Our reference: ECM: 9783432  
Contact: Kathryn Saunders  
Telephone: (02) 4732 8567

12 November 2021

**Request for Advice – Request for Further Information for Oakdale West Estate Stage 3 - SSD-9794683 at 2 Aldington Road Kemps Creek**

04 Southern Link Road Frontage
Typical Street Section - Scale 1:50 @ A1

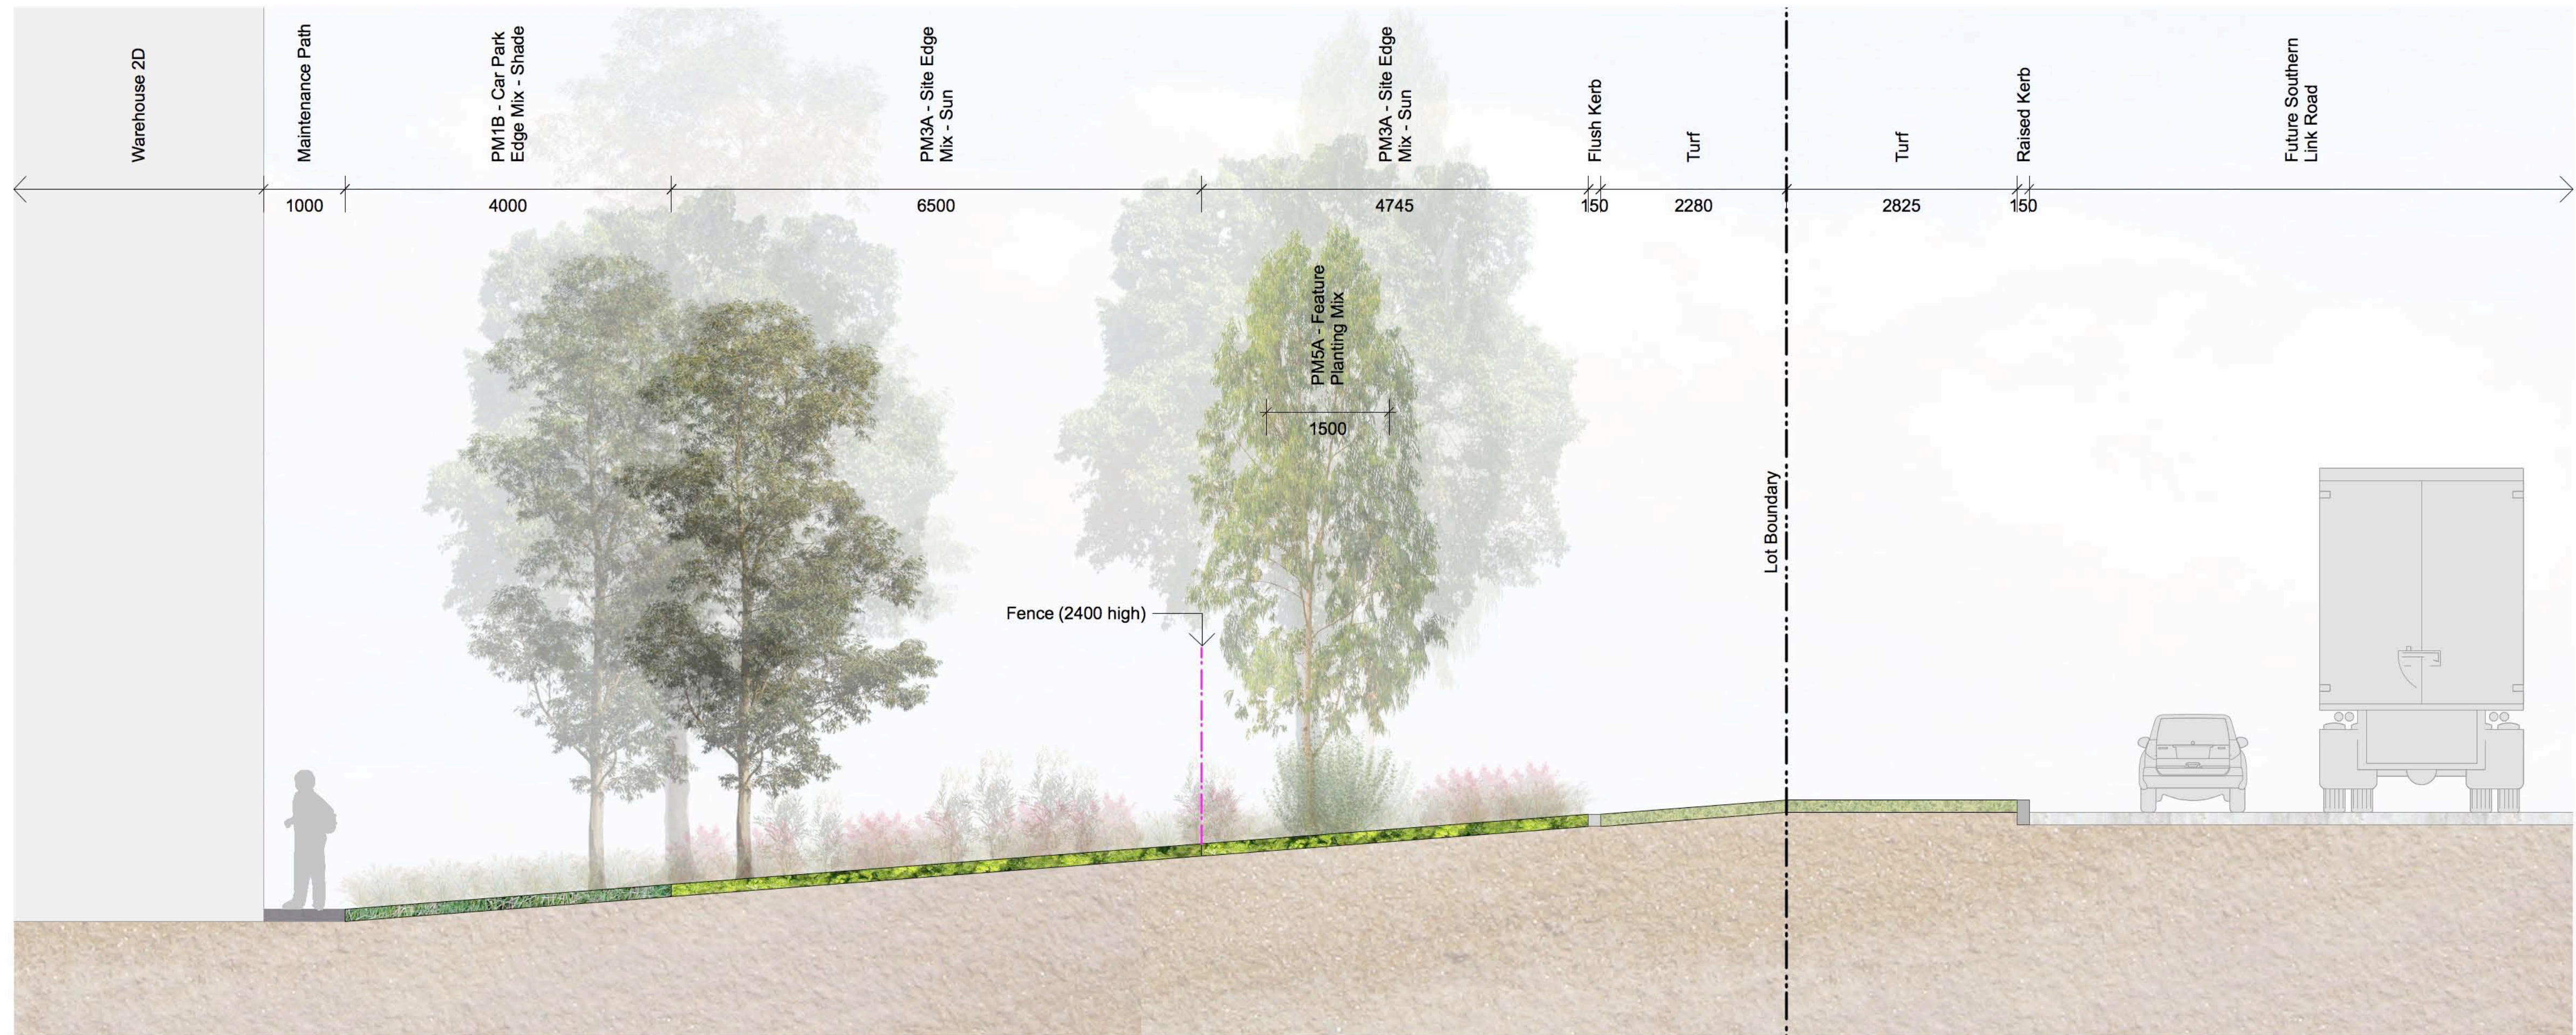
Further, Section 05 on landscape plan no. L.SK.202 revision C indicates the landscape setback to the future Southern Link Road is 6.579m wide exclusive of the proposed internal driveway kerb and proposed catch drain.

This is not consistent with the landscape plans which indicate 7.150 landscaped setback.

- Section 03/LSK.202 is misleading in terms of retaining wall height. Spot levels indicate a change in level of approx. 8m. The section shows a wall height of approx. 2m. All retaining walls and fences on top of walls, seen from the public domain, should be densely screened to reduce visual impact and create microclimates suitable for plant growth e.g. not radiated heat from wall materials.
